Our ref: DOC22/738411-8

John Hunter Hospital Health and Innovation Precinct Project (SSD-9351535 MOD 2) – Vegetation Clearing

John Hunter Hospital Health and Innovation Precinct – Vegetation Clearing (SSD-9351535 MOD 2) – Review of the BDAR

FIGURE 2.1
Landscape Features

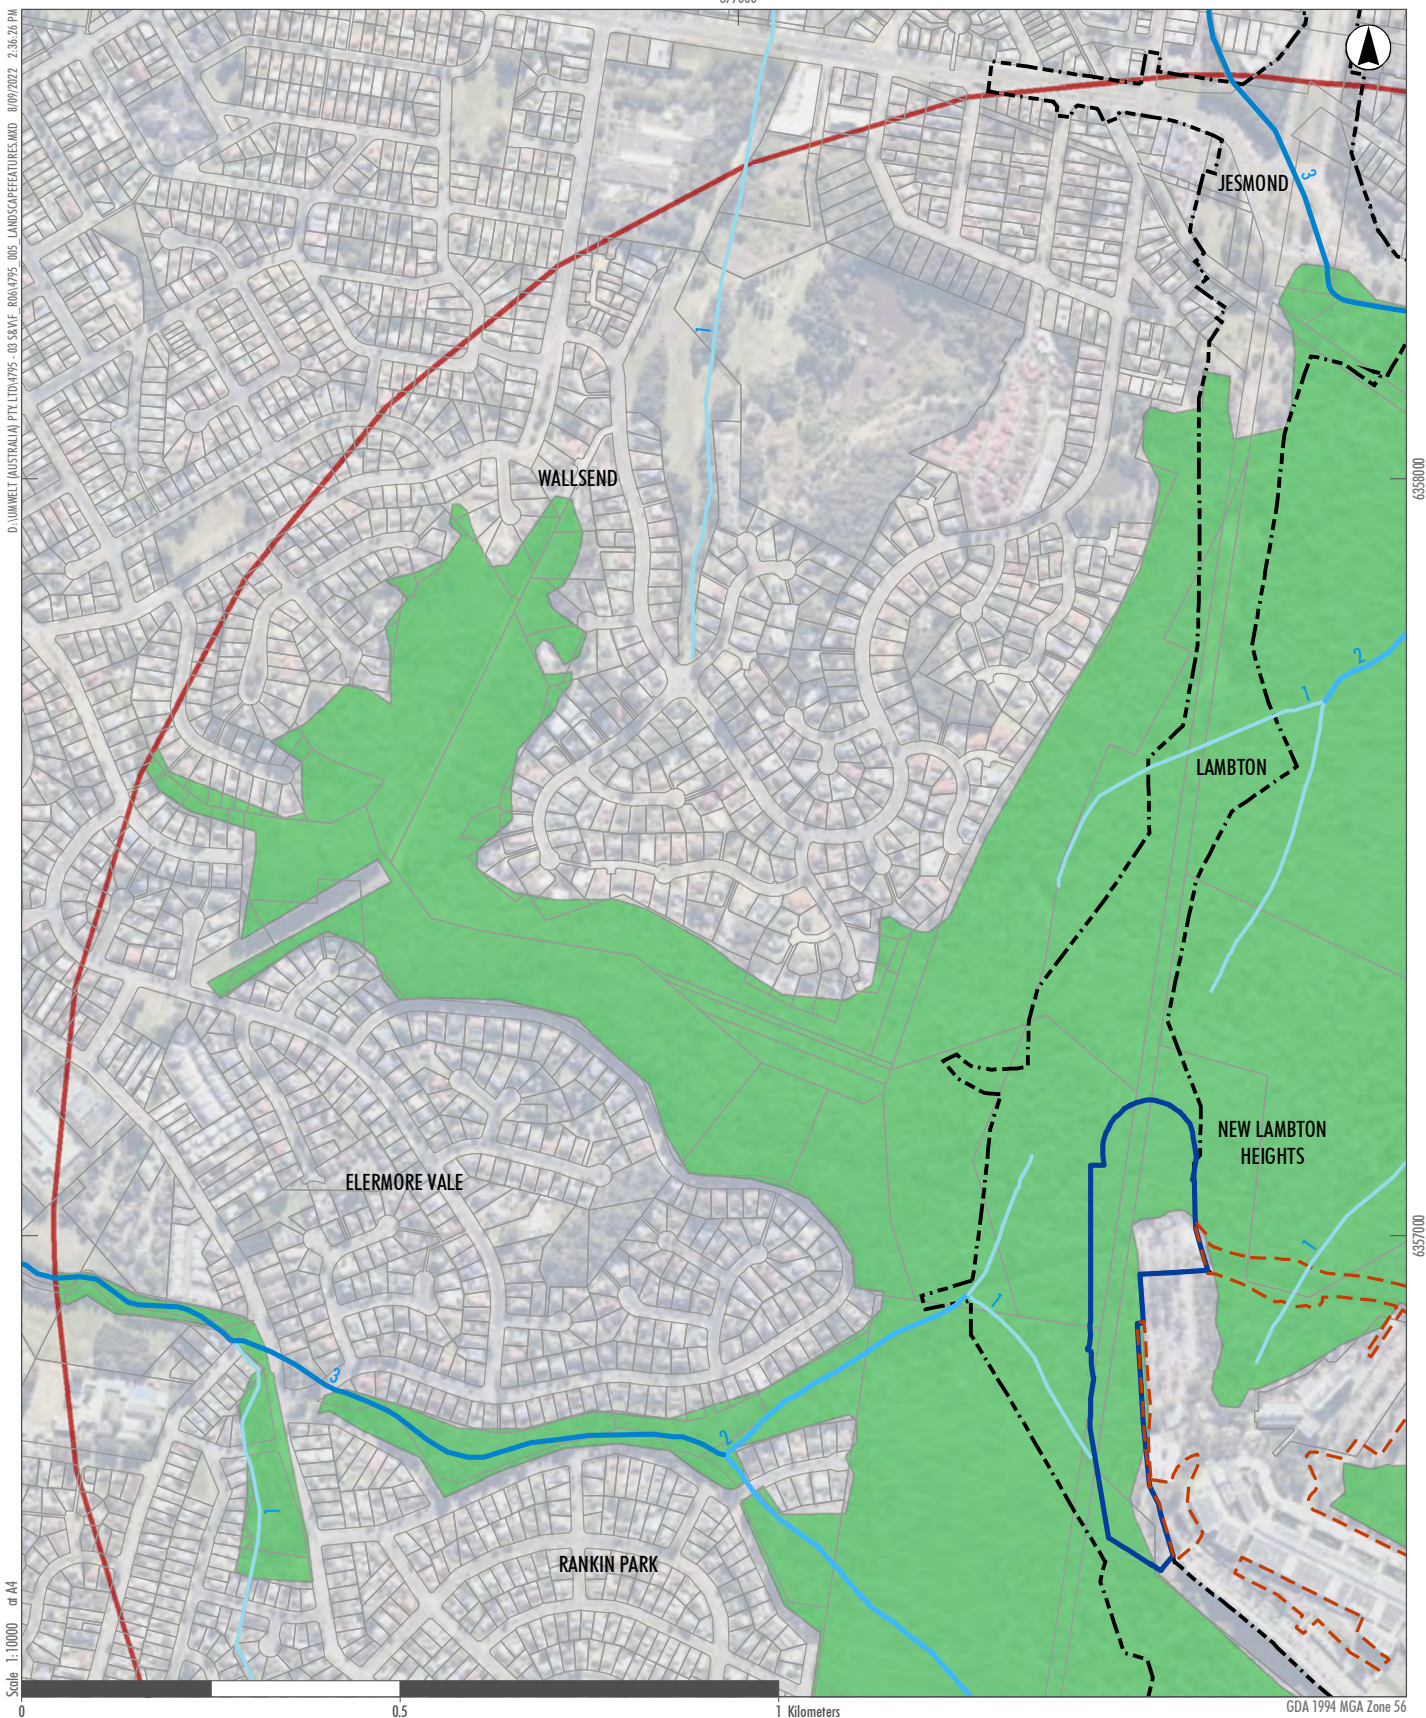
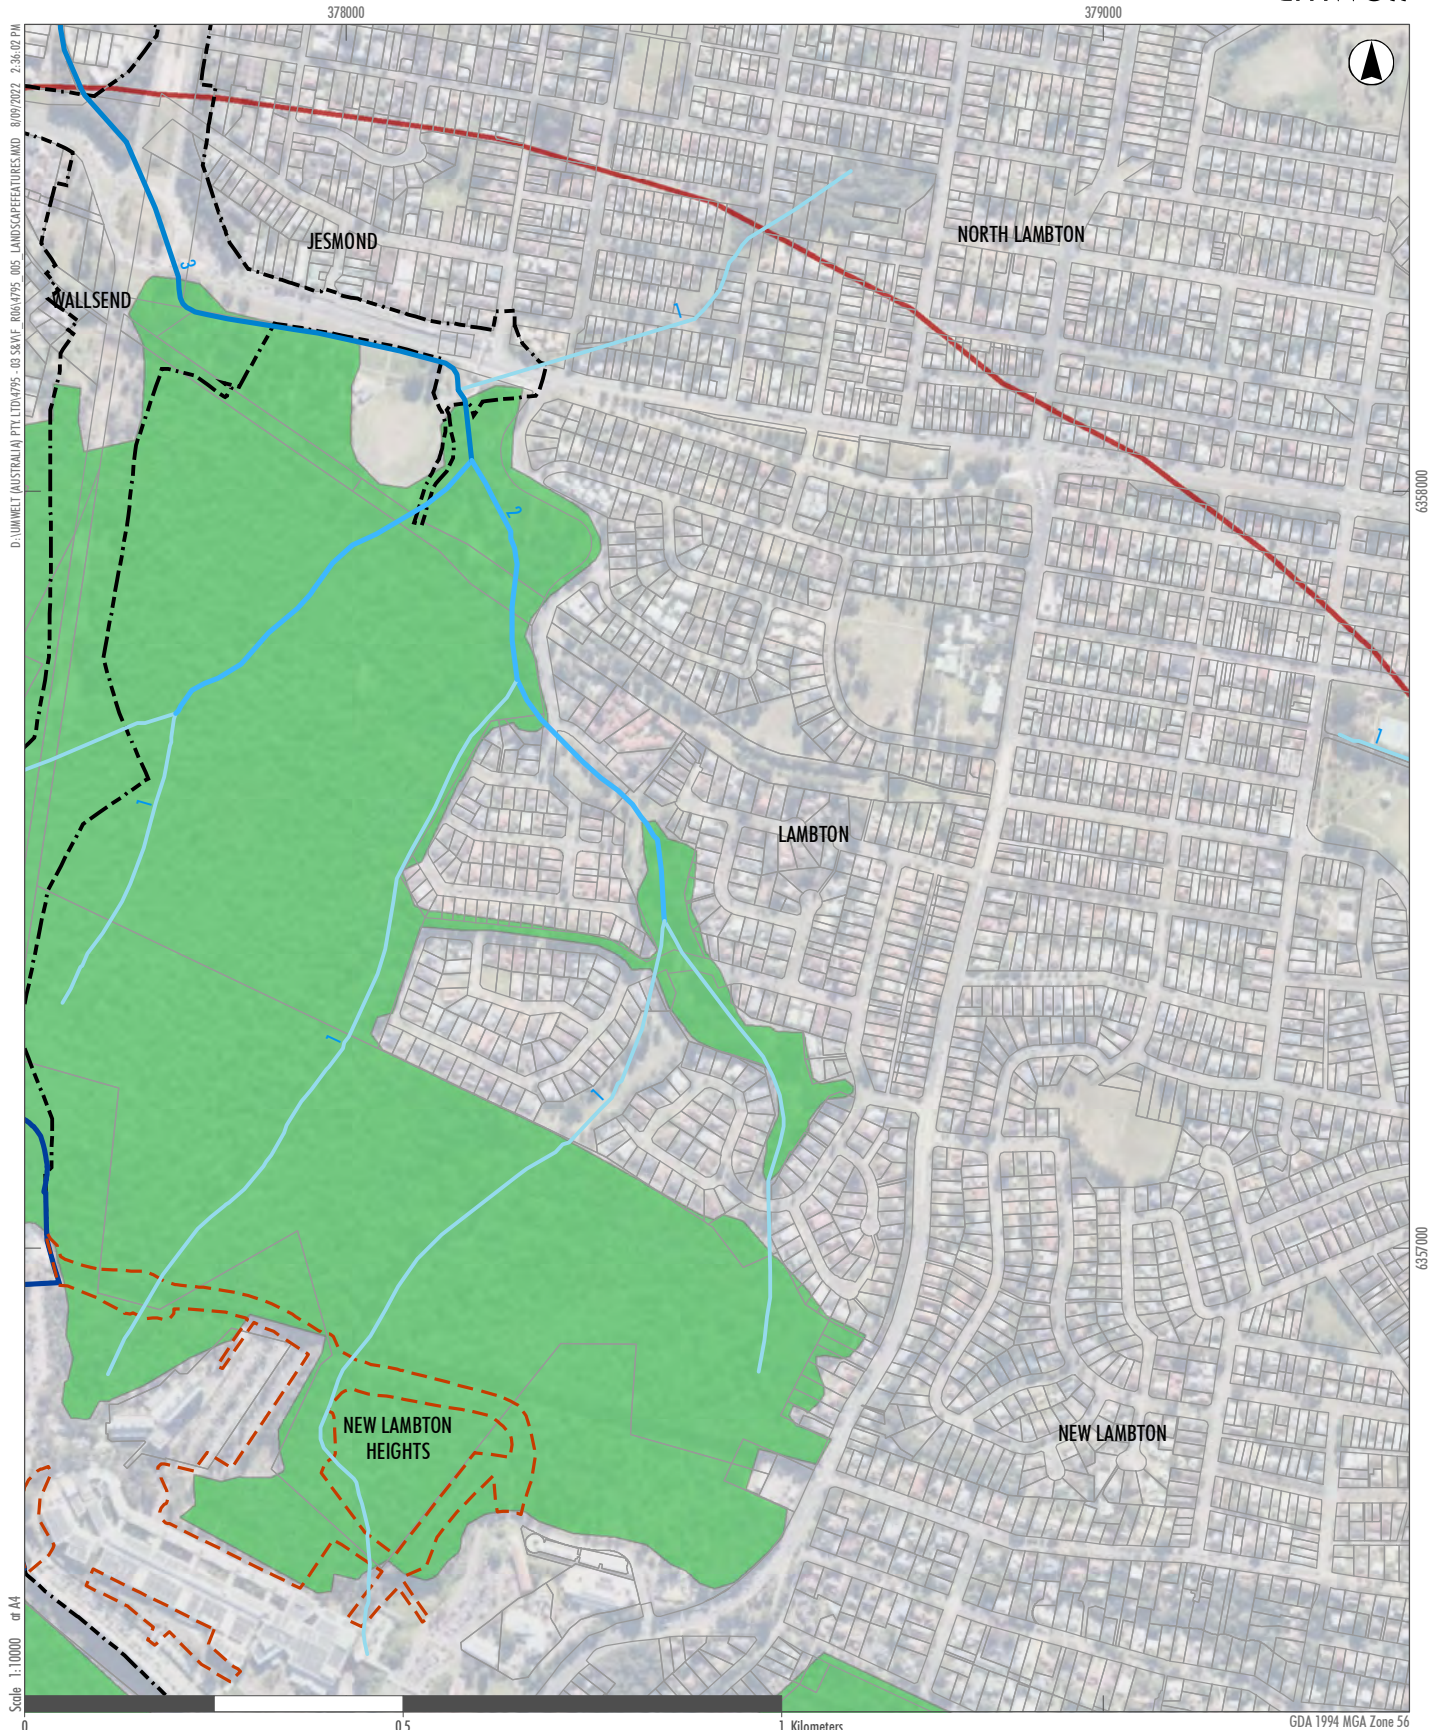
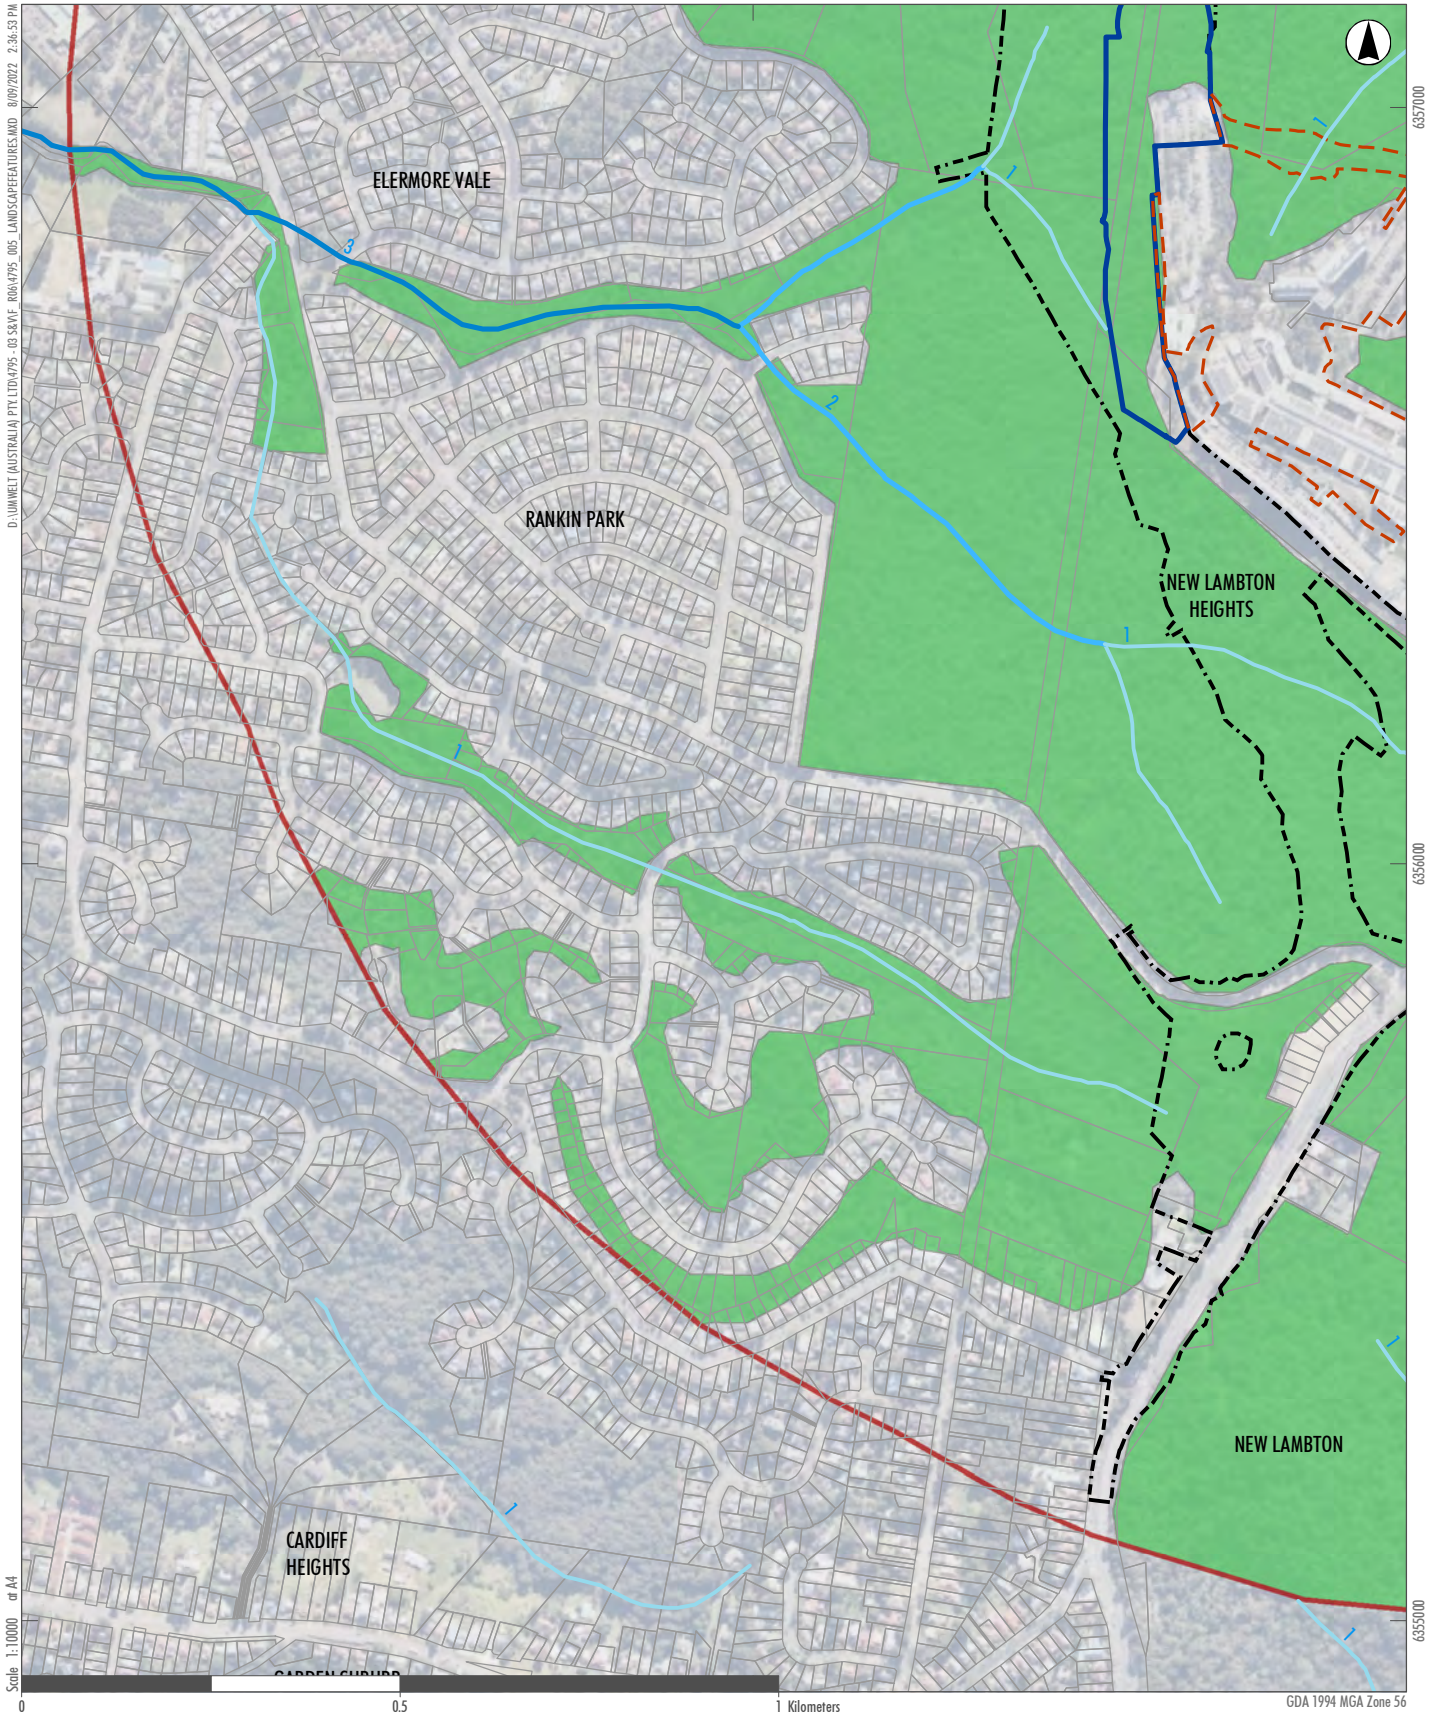
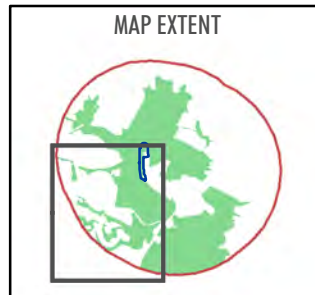
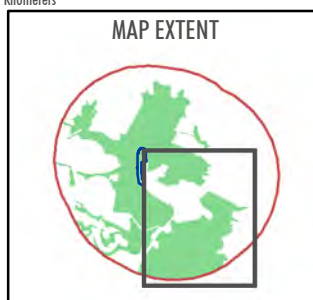
Figure 2.1 'Landscape Features' shows the mapped extent of native vegetation and is presented at a scale of 1: 24,000. However, Section 4.1 of the BAM 2020 requires that mapped native vegetation extent is presented at no more than 1:10,000, so that it is clearer for the

reader to see. BCD therefore recommends that either Figure 2.1 is redrawn to be at no more than 1:10,000 scale, or that a new map at no more than 1:10,000 is produced showing the extent of native vegetation.

BCD recommends a map showing the extent of native vegetation is provided that is at no more than 1:10,000 scale in order to meet requirements of the BAM 2020.
